# CITY OF ALBUQUERQUE

May 15, 2017

**RE: Family Dollar Store / 4<sup>th</sup> St. NW**  
**Grading Plan and Drainage Report**  
**Stamp Date: 4/28/17**  
**Hydrology File: H14D107**

Based upon the information provided in your re-submittal received 4/28/2017, the Grading Plan and Drainage Report is approved for Building Permit.

C-100

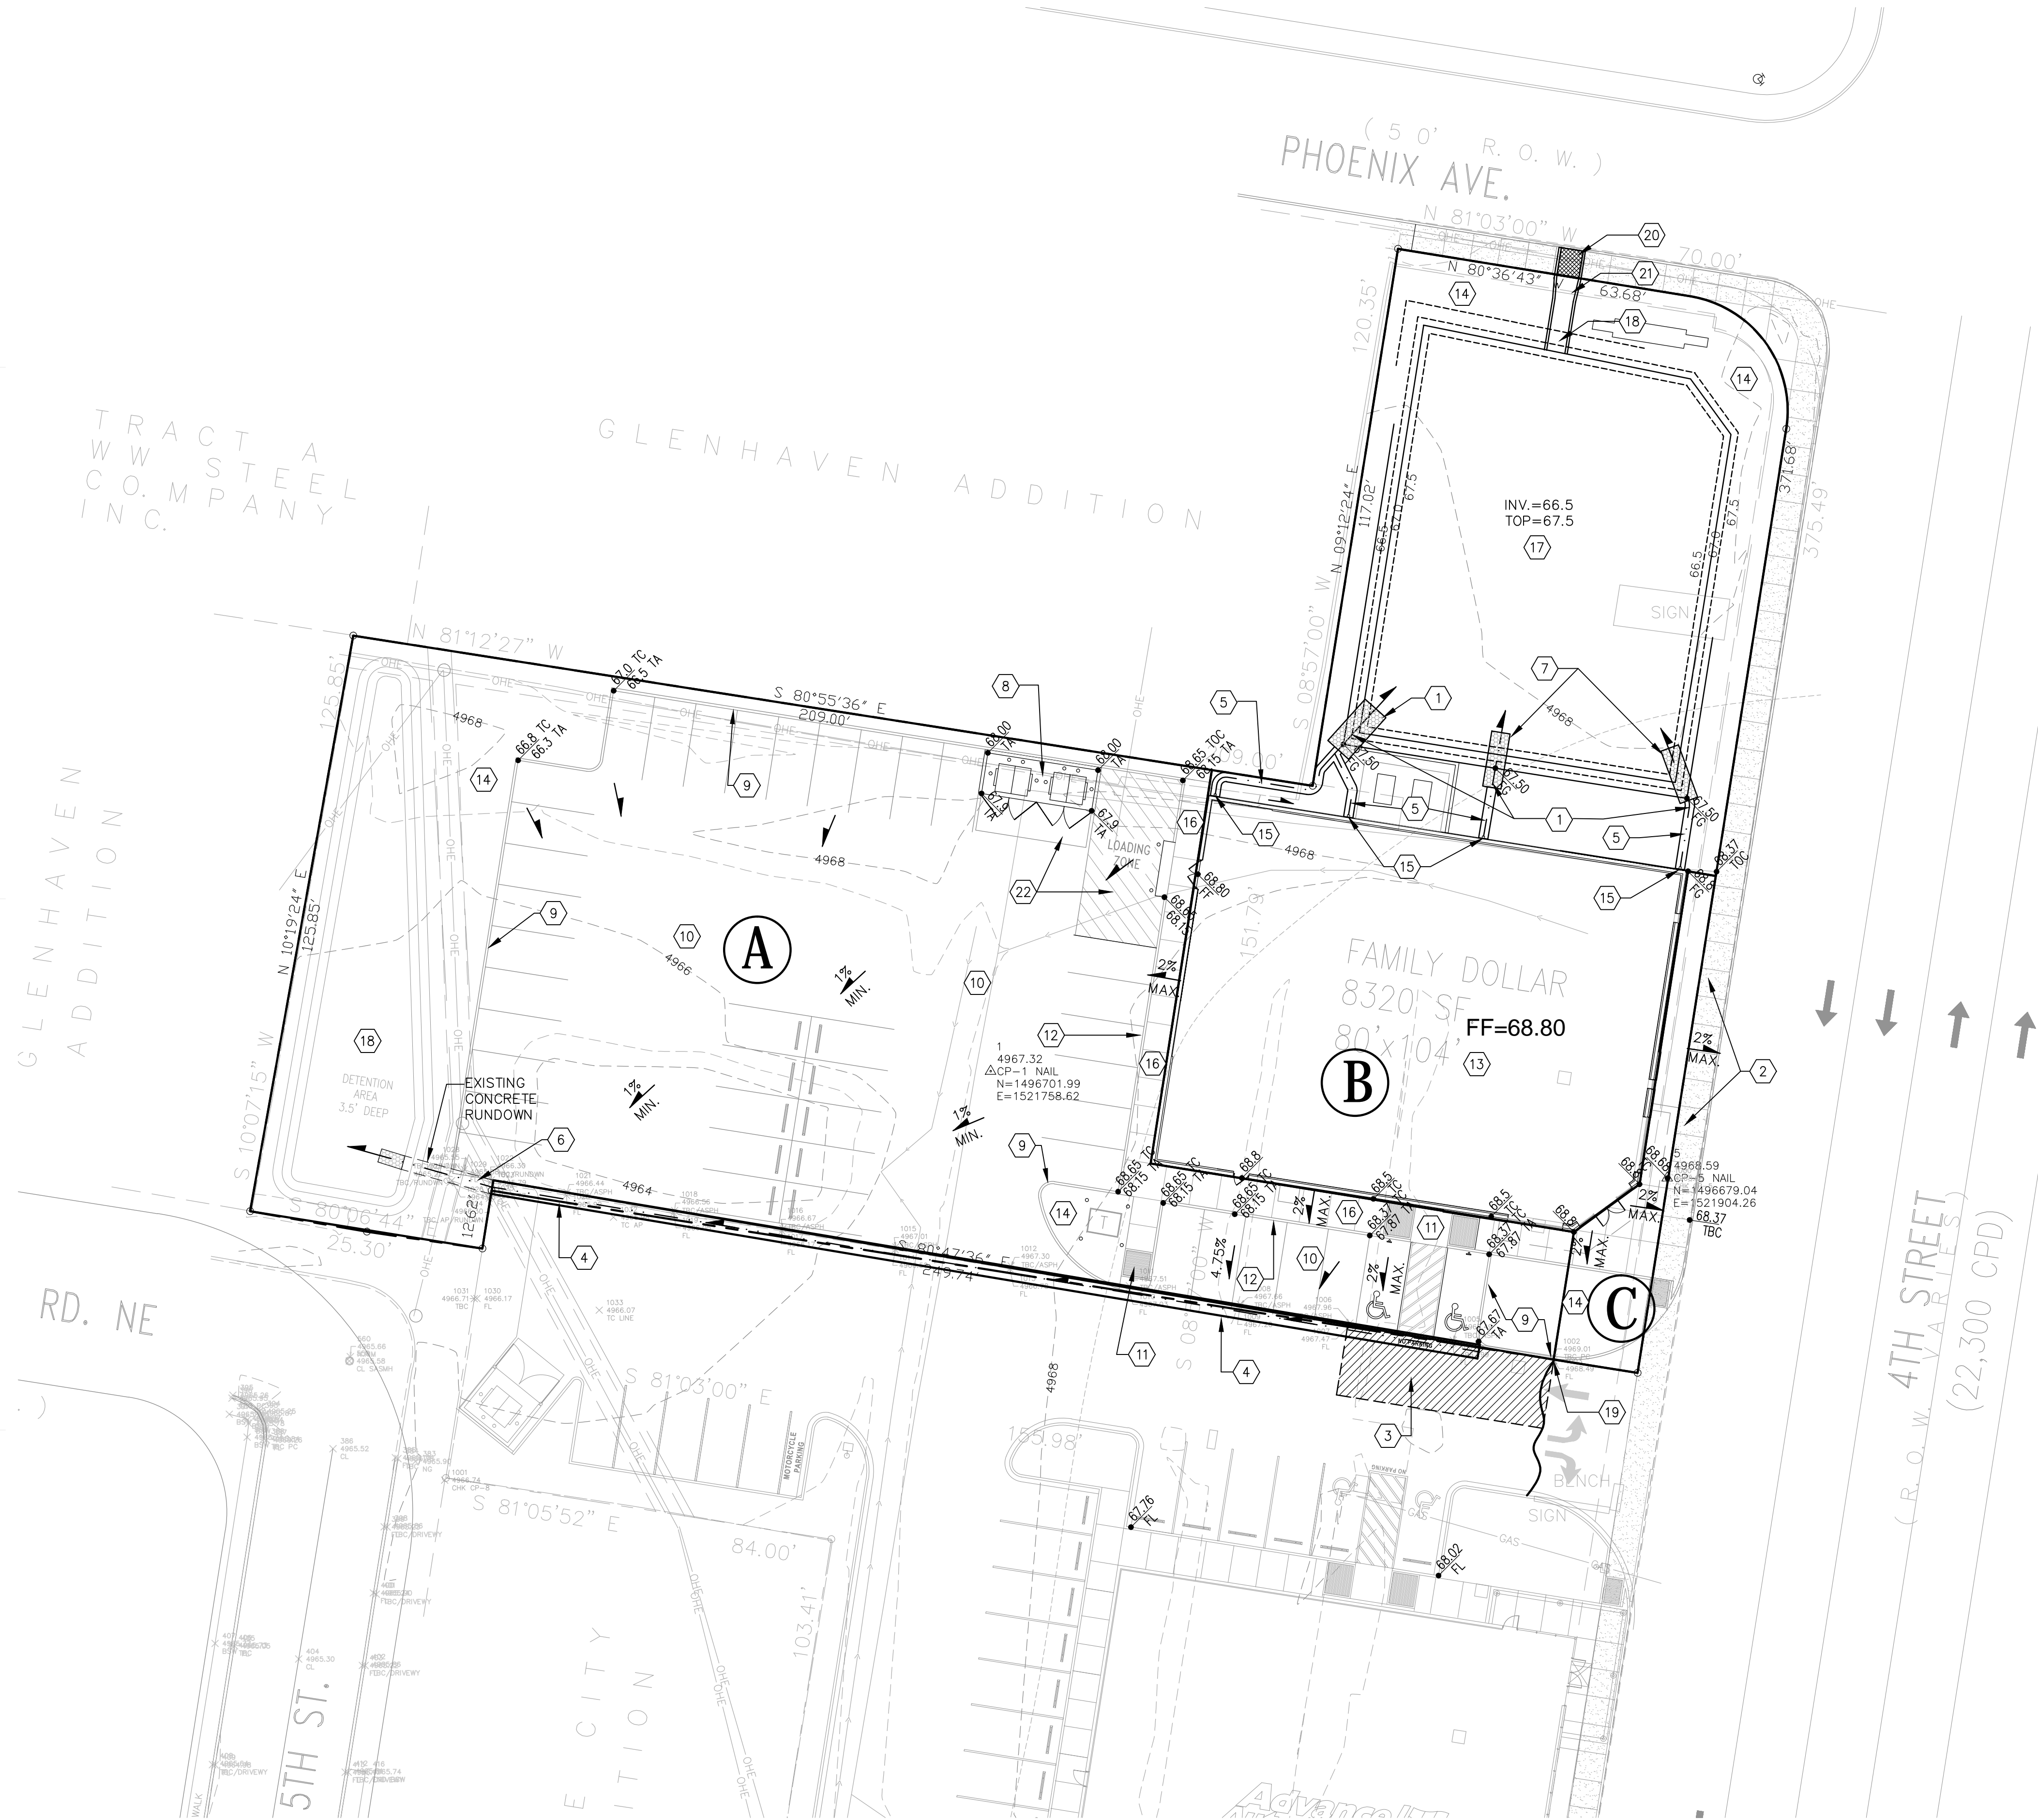
1. Under the existing conditions, it is mentioned that the site is part of an existing master plan. It would have been helpful if you had provided the master drainage plan for information only. That being said, it appears that the proposed water harvest basin 1 on the master drainage plan is bigger and a different shape than what was built as shown on C-101. Please clarify that the volume required and shown in the master drainage plan is being provided for in the as-built basin.

2. Since basin "A" is part of basin "2" of the master drainage plan, it is confusing when trying to compare these two basins since you do not include the exiting impervious from the existing adjacent tract in the drainage calculations. Please provide this existing drainage information. A note under the drainage data will suffice.

*An incorrect base drawing was used to illustrate existing conditions and topography on the first submittal. The new drawing illustrates a pond that is representative of the current as-built conditions. The volume calculations have also been verified.*

*A new Basin D has been added to show the existing runoff calculations from the Advanced Auto parking lot. Basins A and D combined are comparable to Basin 2 of the Master Plan.*

C-101

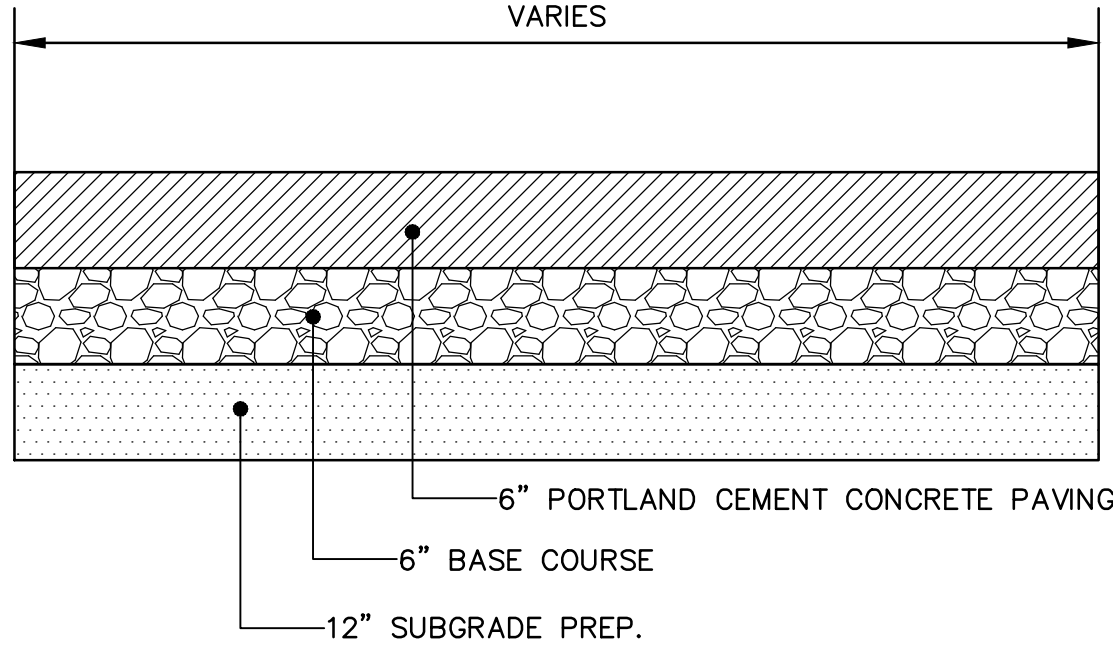
3. Please provide the flowlines for all the proposed concrete channels at both ends (the roof drain and the outfall).

4. Please provide the toe elevations for the proposed rip rap rundown.

5. Under Keyed Notes #18, the invert elevation is stated as 60.0. However, the exiting harvest area has a top elevation of 66.0 and the pond is 3.5 depth, so shouldn't the invert elevation be shown as 62.5 instead of 60.0?

6. Under Keyed Notes, there are two #18s. Please renumber the last five numbers and also change the corresponding numbers on the plan.

7. Please provide the flowline elevation of the start of the proposed valley gutter.

8. Please provide the existing flowline elevation of the existing concrete channel where the proposed valley gutter will connect.

9. Please provide the TC & TA for the corner of the proposed parking near the existing concrete rundown.

10. It appears that the above proposed parking corner is over the existing concrete rundown. If this parking spot is needed, then the existing concrete rundown will have to be replaced or relocated to avoid the construction conflict. Please clarify.

11. Please provide the top and bottom elevation on the shown contours of the existing water harvest basin.

*Spot elevations have been provided at both ends of the concrete channels.*

*Spot elevations have been provided at the toe of the rip rap rundowns.*

*Spot elevations have been provided for the top of pond elevation and the bottom of the pond elevation based on the as-built survey. Keyed note #18 has been updated to reflect this information.*

*This has been corrected.*

*A spot elevation has been provided at this location.*

*A spot elevation has been provided at this location.*

*A spot elevation has been provided at this location.*

*The site plan has been modified.*

*Spot elevations have been provided for the top of pond elevation and the bottom of pond elevation.*
